**STATION NORTH AND STATION SOUTH SITE WITHIN THE NORTH RYDE
STATION URBAN ACTIVATION PRECINCT (SSD 6265)**

Thank you for your letter dated 8 April 2014 inviting Transport for NSW (TfNSW) to comment on the above. Please accept this as a joint TfNSW and Roads & Maritime Services (RMS) response.

North Ryde Urban Activation Precinct Station Site North and Station Site South

INTERSECTION DELHI ROAD & ROAD 38
INTERSECTION ROAD 38 & TRINITY ROAD
SCALE 1:500

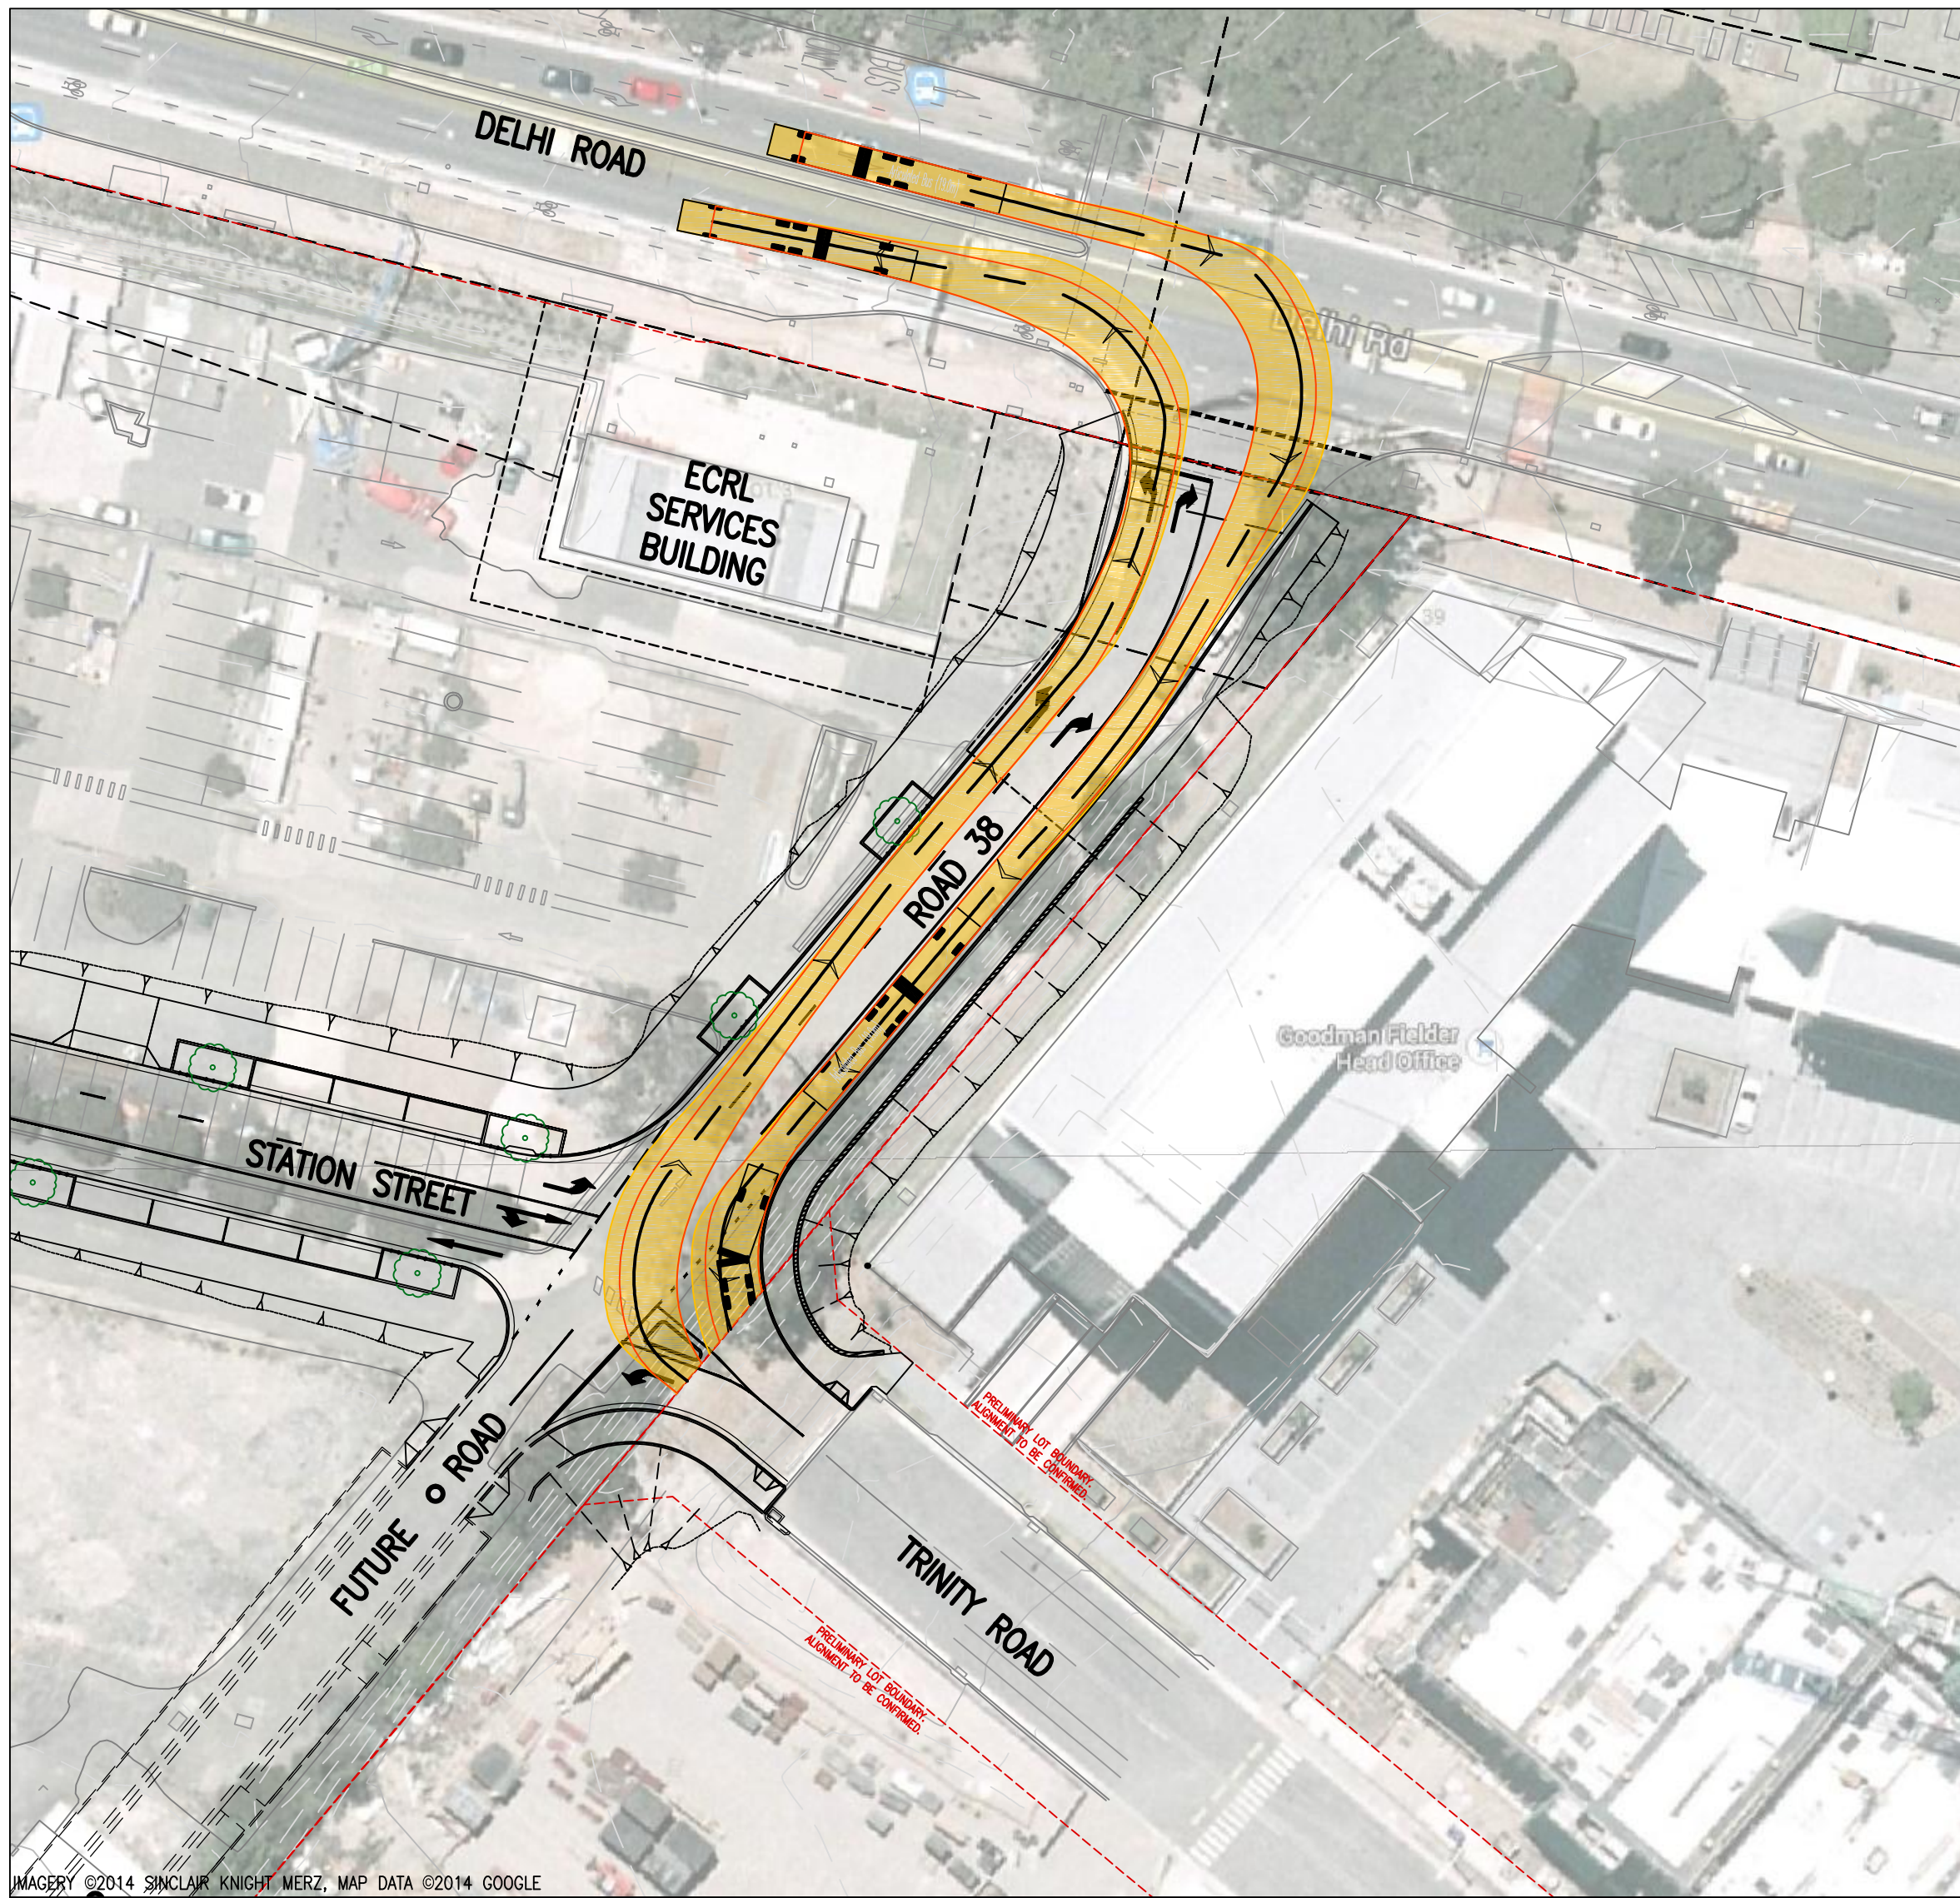
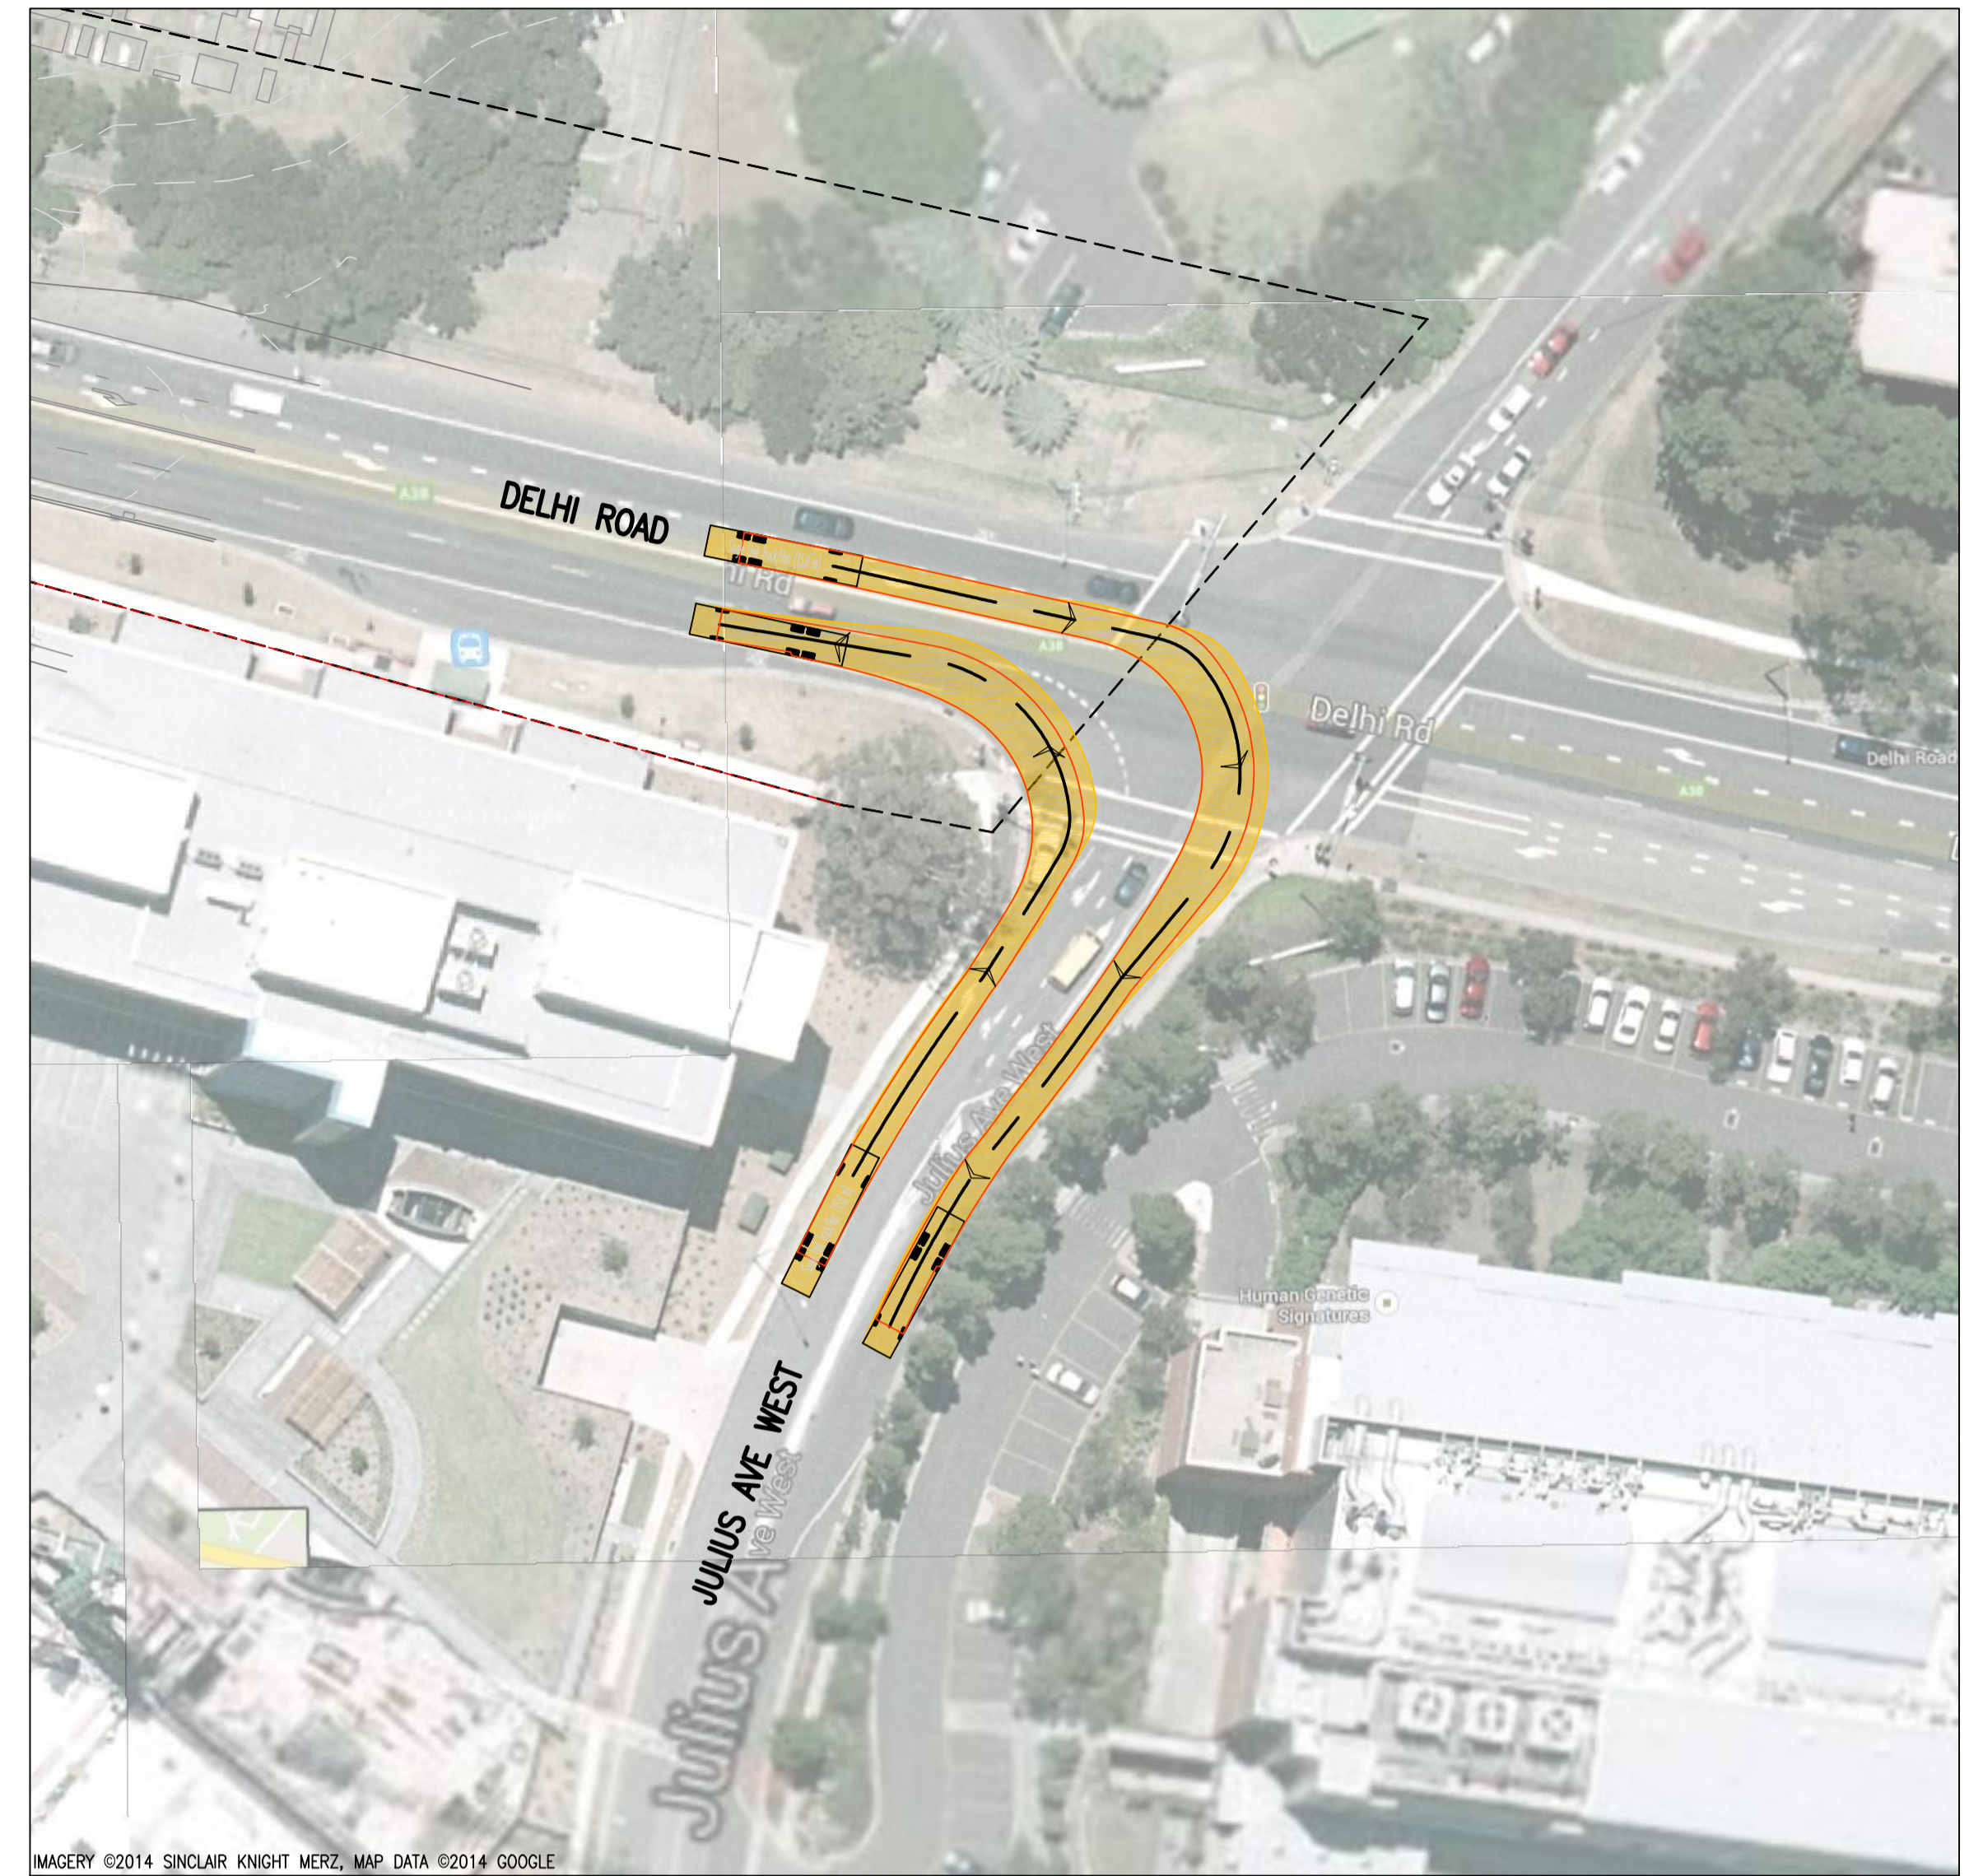
4. Ensuring the Intersection design for Delhi Road/Road 38 intersection is approved by the RMS. Signal plans and traffic signal modelling needs to be provided to the RMS to their satisfaction.

Traffic modelling has been undertaken by modifying the signal timing to reduce the delays along Road 38 at the Delhi Road/Road 38 intersection.

It is not clear from the traffic report how the reduction in delays along Road 38 is achieved in detail. It should be noted that in regard to the proposed changes to signal phasing at Road 38/Delhi Road, Roads and Maritime SCATS system will allocate green time as needed in the future based on existing priorities built into the traffic signal system. These priorities include traffic flow on Lane Cove Tunnel/M2 and Epping Road.

The applicant must provide the details of signal timing used in the traffic model to RMS Transport Management Centre for their review and concurrence.

Figure 4.1 Proposed upgrade of Delhi Road

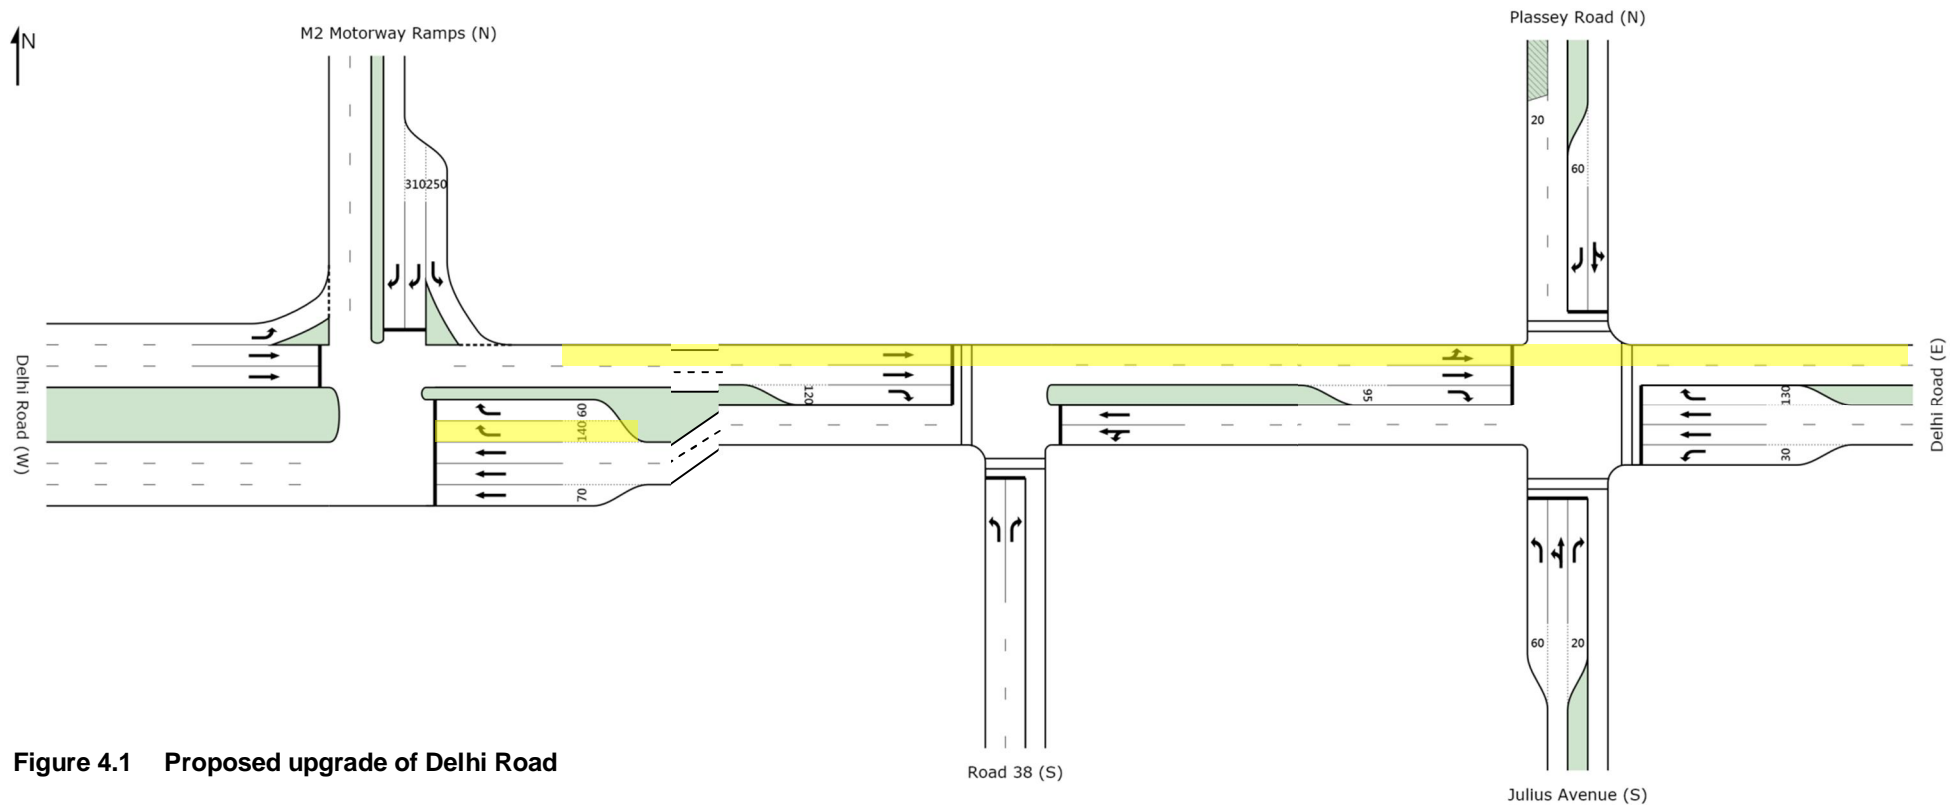
The traffic report prepared for the development application has recommended that the upgrade of a small section of Delhi Road be undertaken. The proposed upgrade is unlikely to improve the overall performance of Delhi Road.

A whole of Delhi Road Strategy needs to be developed to define the future function of this road. Once this strategy is developed then high priority projects that have the potential to improve the overall performance of Delhi Road could be selected for possible expenditure of the offered State Infrastructure Contributions.

TfNSW will continue to work with UGNSW to identify the preferred infrastructure projects that will complement the \$10.4 million funding already committed to ensure optimal improvement are made to improve the traffic flow on the State Road network.

Figure 5.2 Proposed layout of intersection of Road 38 and Station Street

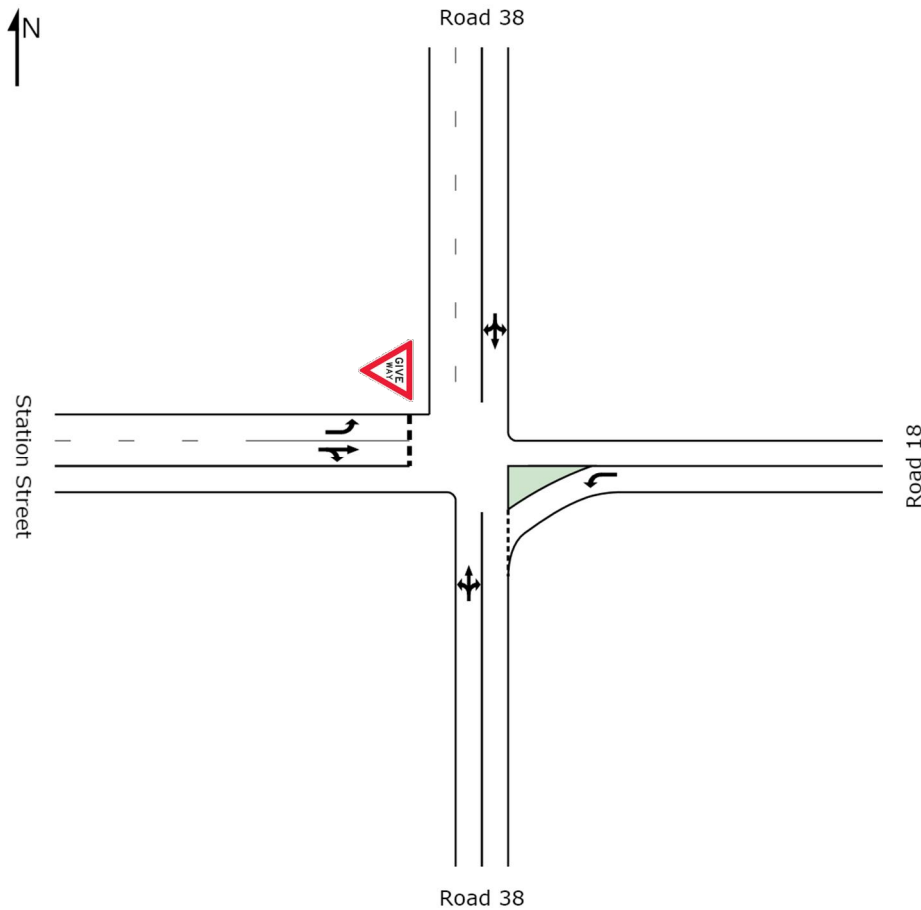
Road 18 currently accommodates marked on-street cycle lanes, however the intersection with Road 38 does not allow for a safe and convenient continuation through to Station Street. The route via Station Street to the pedestrian / cycle bridge currently conflicts with the sub-optimal kiss and ride zone and pedestrians entering the station. While cycle access through this route is strongly supported, the design needs to be revised to ensure safer access for cyclists.

These issues require a redesign of Station Street and the adjoining access road surrounding the local park (which does not appear to meet DCP design requirements with respect to width of carriageways and adjacent footpaths). The intersection of Station Street, Road 18 and Road 38 should also be redesigned to allow vehicle access to the Riverside Business Park for kiss and ride and taxi pick-up / drop-off.

- the intersection of Road 18 and Station Street be redesigned to accommodate through cycle access.
- Station Street be redesigned to provide dedicated cycle access or extension of the shared zone
- pedestrian and cycle access is provided between Station Street and the proposed pedestrian/cycle bridge over Delhi Road.
